**Consultation Response from KC,
Highways Development Management**

2025/92995 Land Adj, Winney Bank Lane, Wooldale, Holmfirth, HD9 1US

Date Responded: 21/01/2026

Responding Ref: K12-5/26

PROPOSED CONCEPT AND OVERVIEW

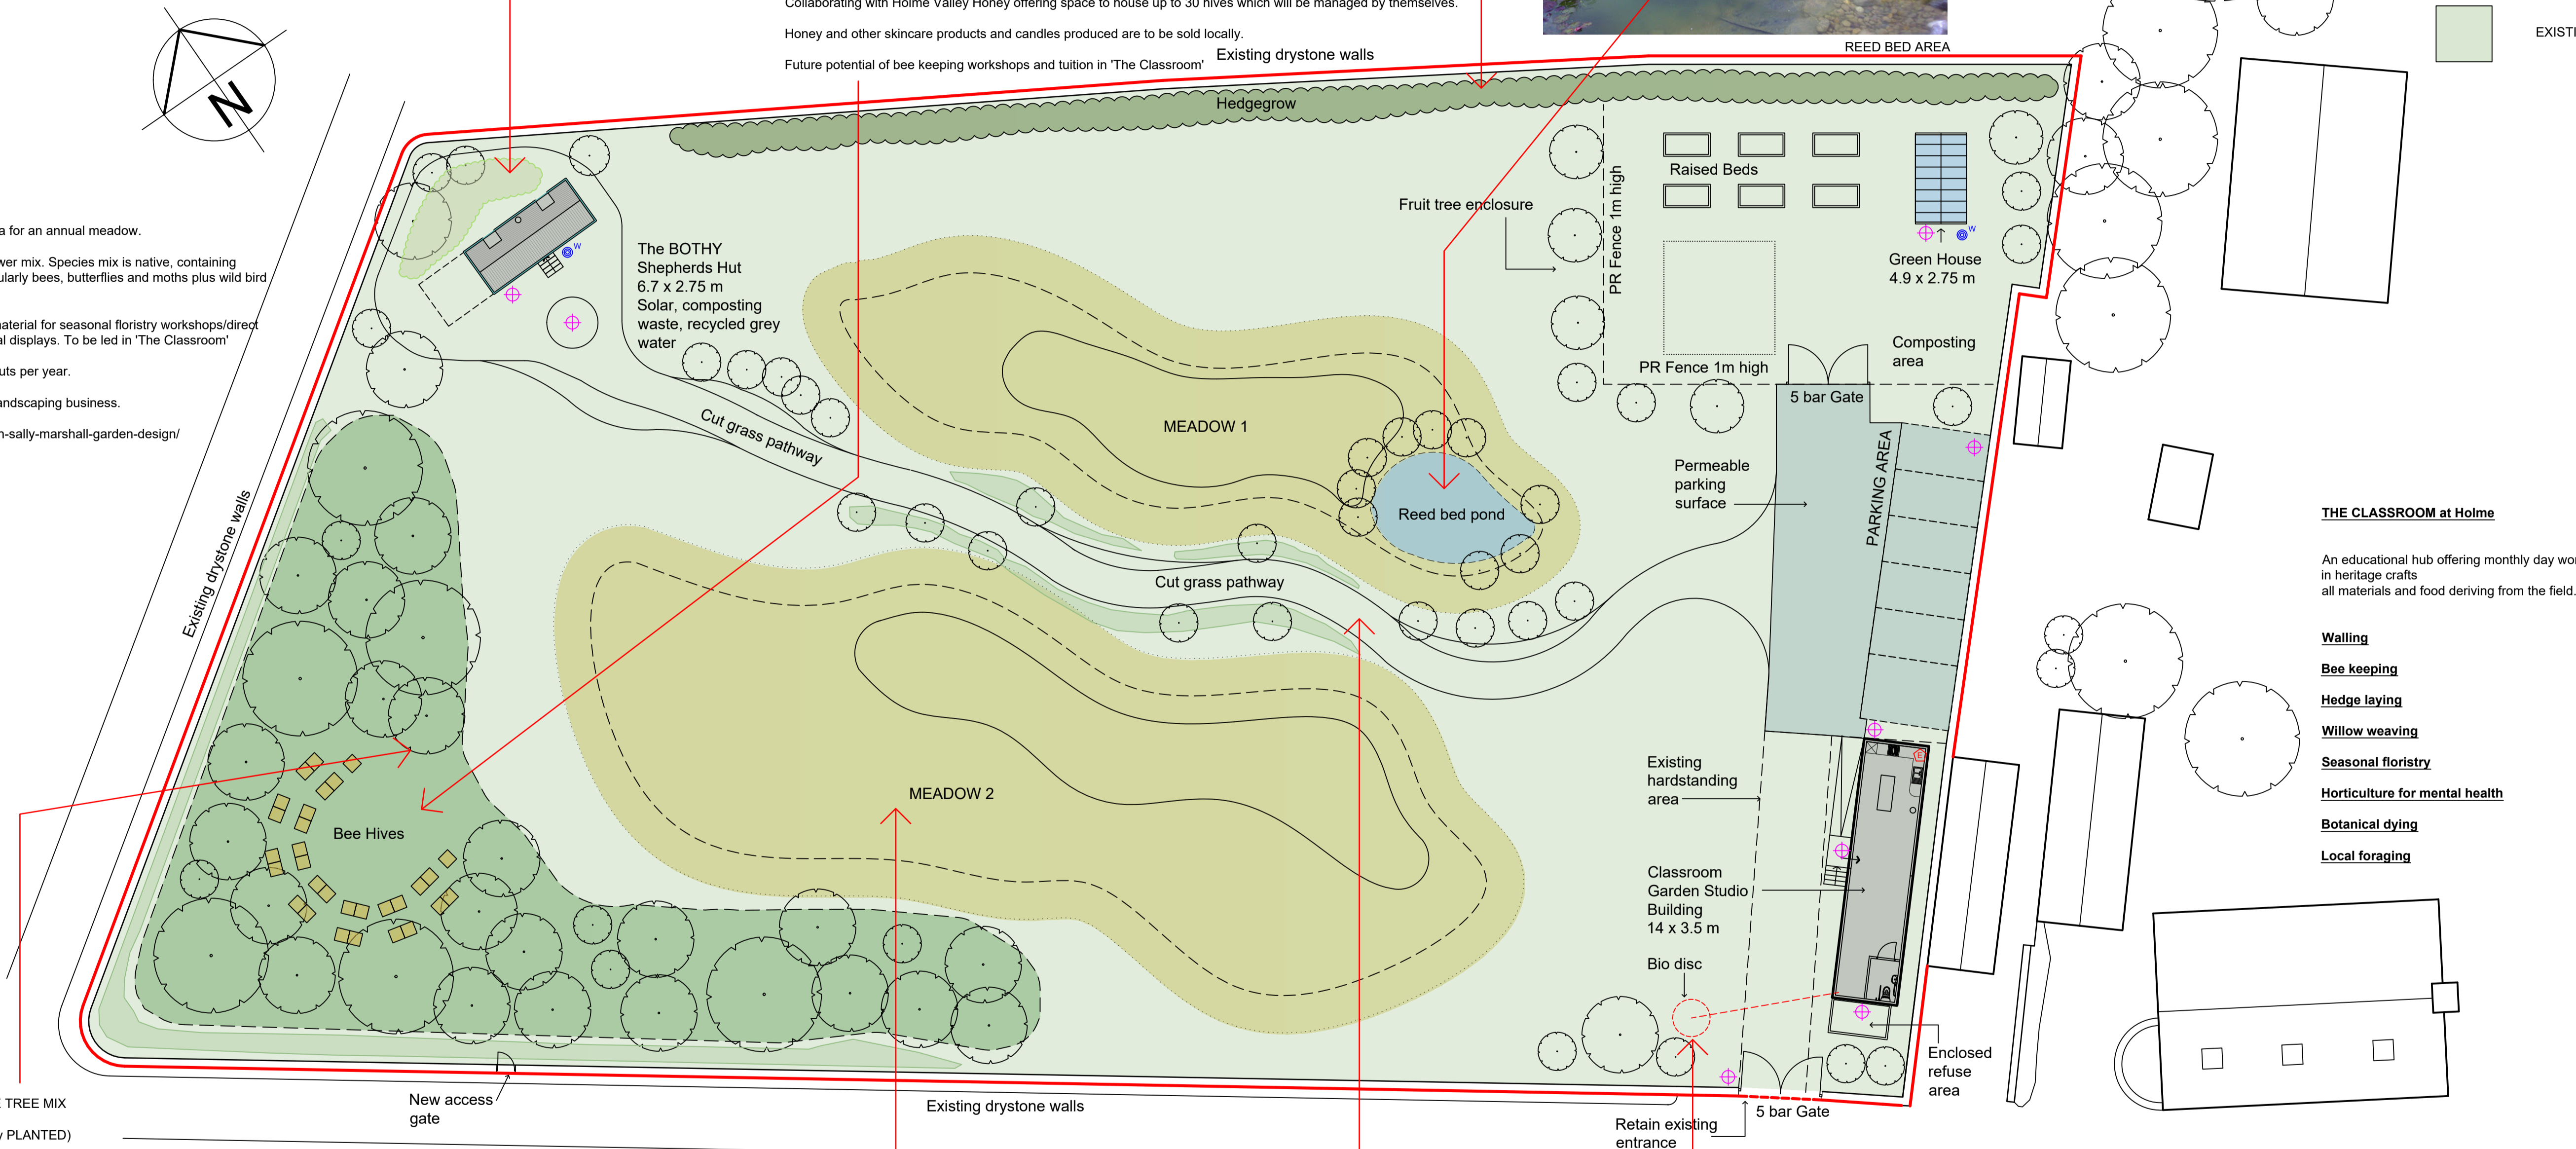
The red line boundary for the application needs to be extended to the adopted highway to demonstrate that vehicular access can be achieved.

A revised plan showing the amended red line boundary should be submitted.

For a 30mph speed limit sight lines of 2.4m x 43m should be achievable and demonstrated on a suitable plan, any shortfall of this requirement should be in accordance with 85%ile wet weather speed readings (if below 30 mph).

A revised plan showing the required sightlines can be achieved should be submitted

Six car parking spaces are proposed; however, no information has been provided to justify if this number of spaces is adequate to meet the demand.

Potentially one space could be used by the holiday let and two spaces by staff. This would leave 3 spaces for 10 customers and may not be enough.

For example. How will the groups/classes attend? Will they be individual or are they from local schools, clubs, etc? If so, will provision be required for a school minibus, together with a larger internal turning area.

The site layout and number of parking spaces should ensure that the parking can be accommodated on the site and not overspill onto the public footpath and further information on the operation of the site is required.

The approved vehicle parking areas will need to be surfaced and drained in accordance with the Communities and Local Government; and Environment Agencies 'Guidance on the permeable surfacing of front gardens (parking areas)' published 13th May 2009 (ISBN 9781409804864) as amended or superseded.
